8. ~~Project# 1010278~~
15DRB-70063 MINOR - PRELIMINARY/
FINAL PLAT APPROVAL  THE SURVEY OFFICE agent(s) for CLYDE CRUTCHMER request(s) the above action(s) for all or a portion of Tract(s) A, **FEDERAL PLAZA** zoned SU-1 (O-1), located on MONTGOMERY BETWEEN SAN MATEO AND MADEIRA containing approximately 8.071 acre(s). (G-18) **THE PRELIMINARY/FINAL PLAT WAS APPROVED WITH FINAL SIGN OFF DELEGATED TO WATER AUTHORITY FOR ESTABLISHMENT OF SEPARATE WATER ACCOUNTS AND TO PLANNING.**

Project #: 1010278 Application #: 15DRB-70063

Project Name: Federal Plaza

**CITY OF ALBUQUERQUE
PLANNING DEPARTMENT
November 19, 2014
DRB Comments**

**SITE SKETCH OF  
PROPOSED TRACTS A-1 & A-2  
FEDERAL PLAZA  
CITY OF ALBUQUERQUE  
BERNALILLO COUNTY, NEW MEXICO  
JANUARY 2015  
SHEET 2 OF 2**

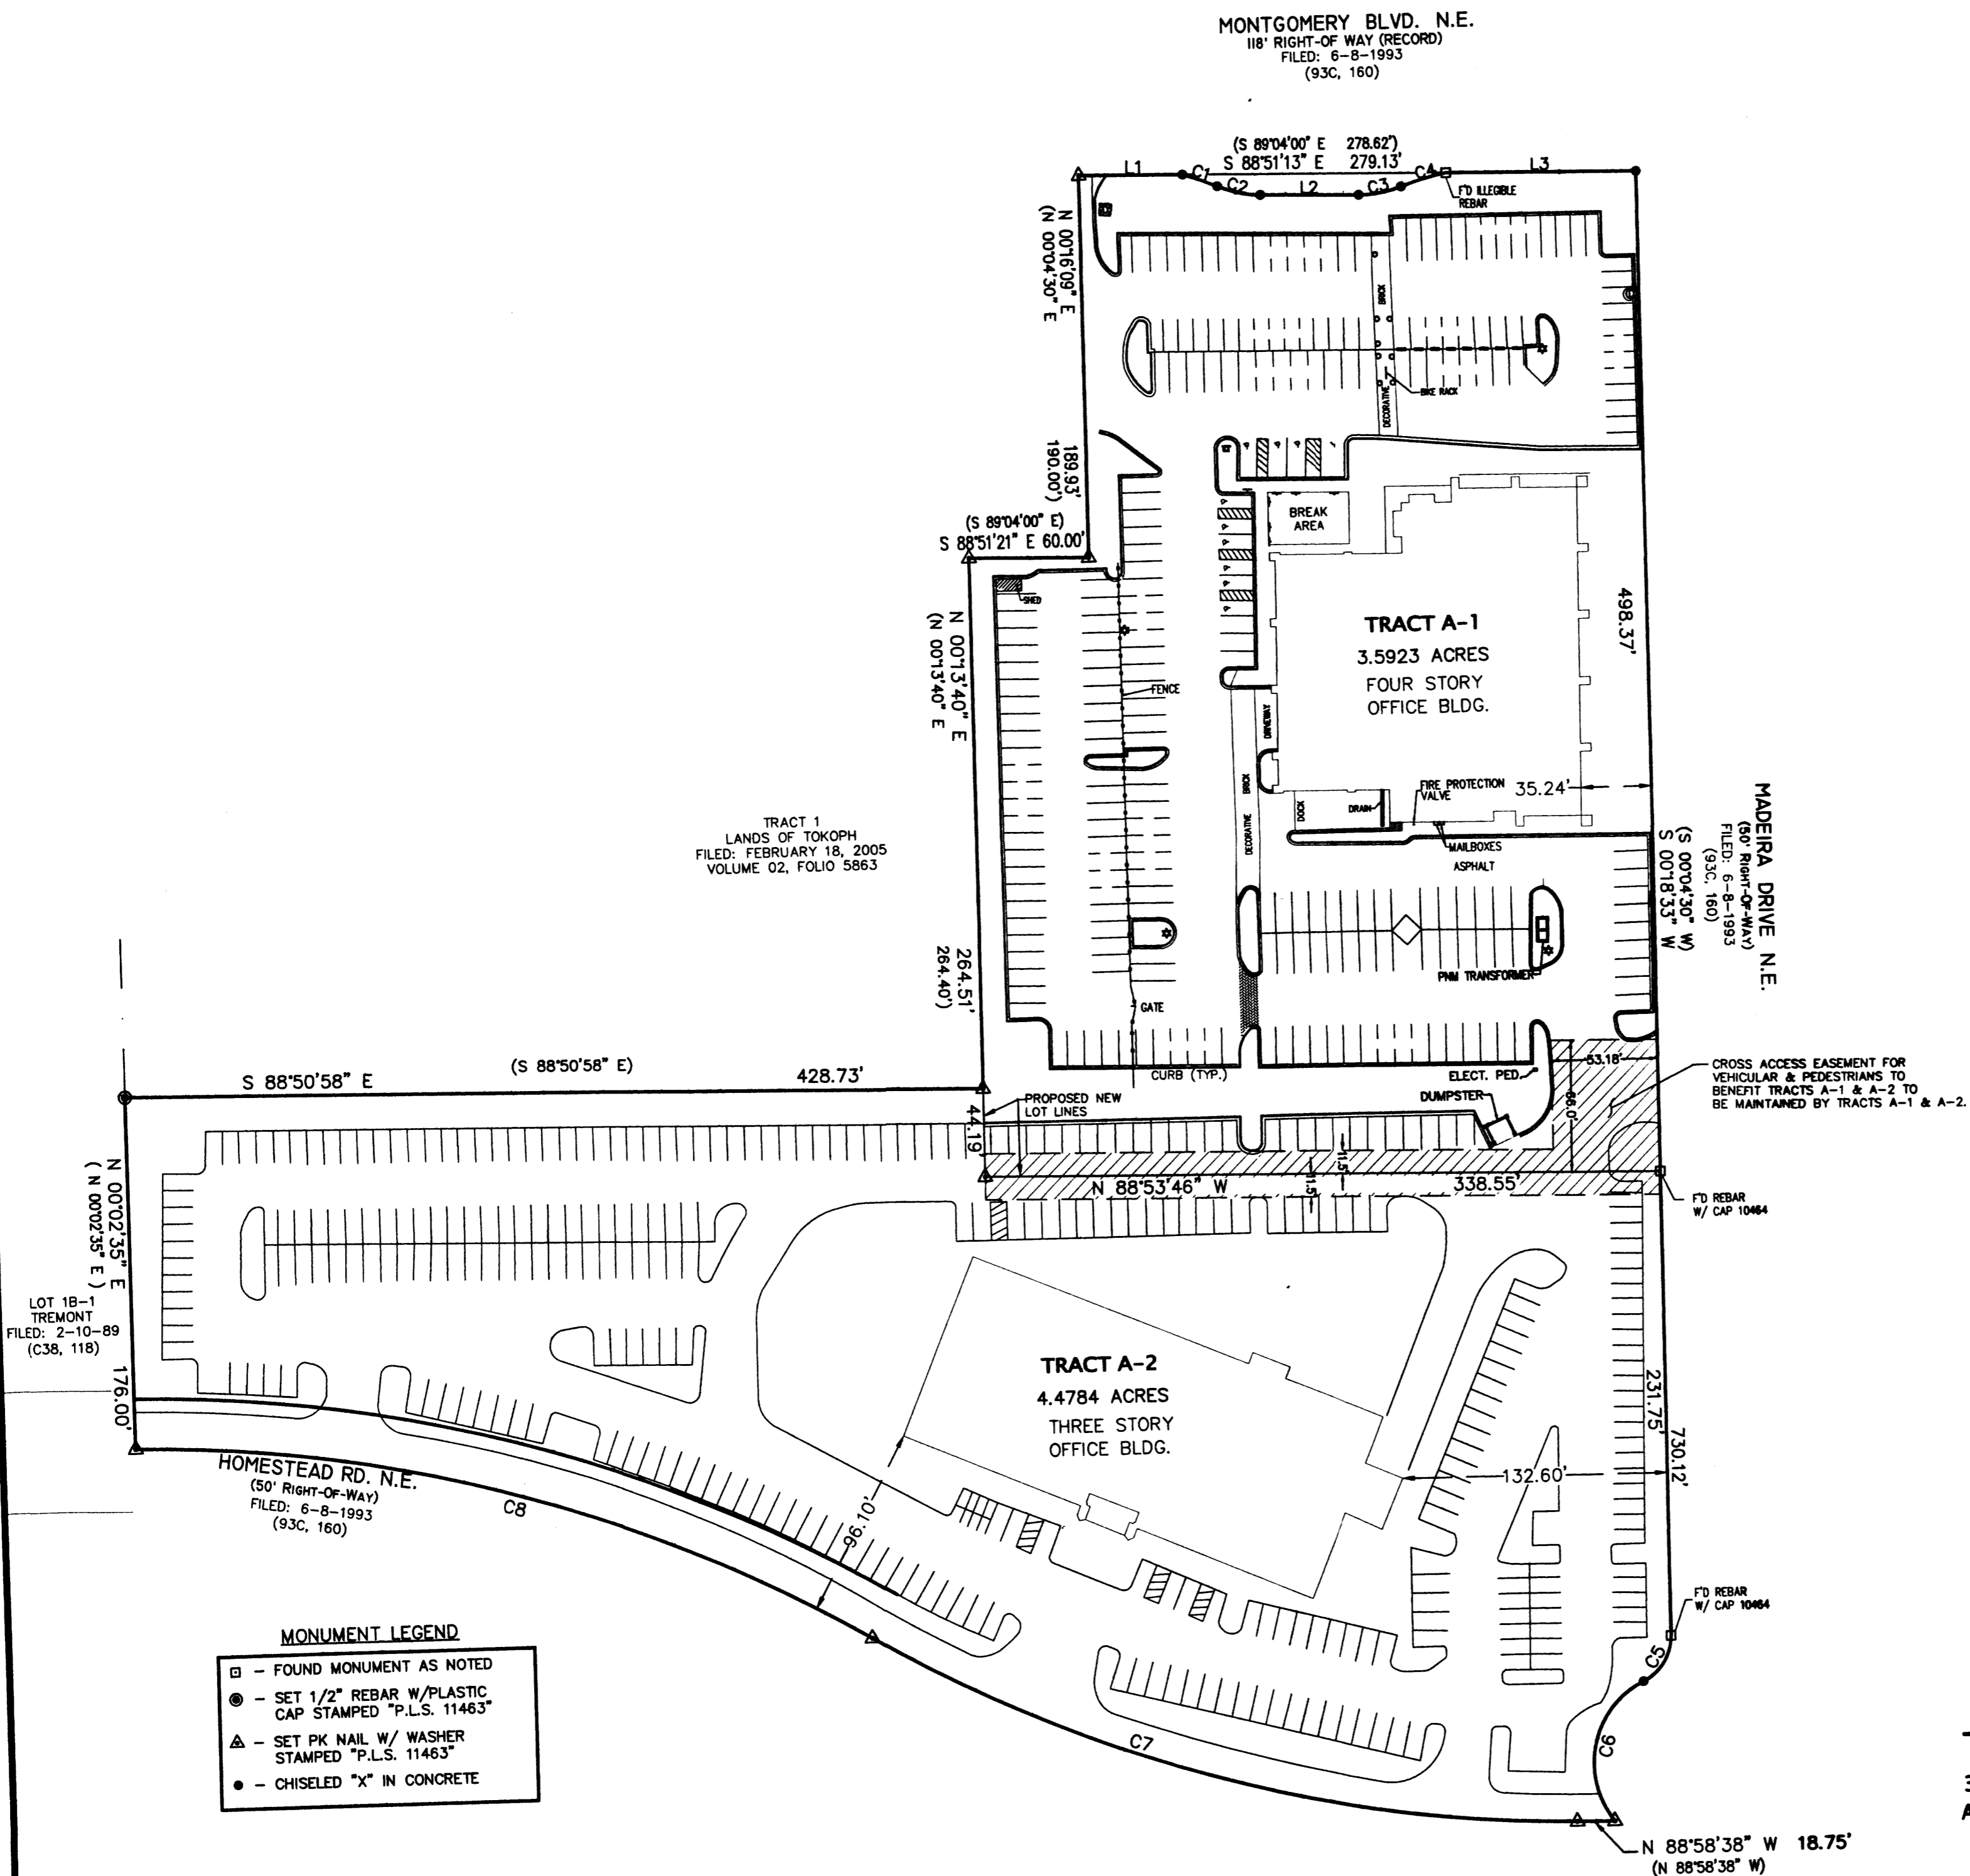
The site is an SU-1 zoned site. As a result, the plat must conform to an approved site development plan. More detailed sketch plan needed: parking calculations (required and provided) need to be shown, and an extended easement is needed to access parking spaces within the new lot(s).

The zone boundary needs to be identified on the final plat (without designating the categories).
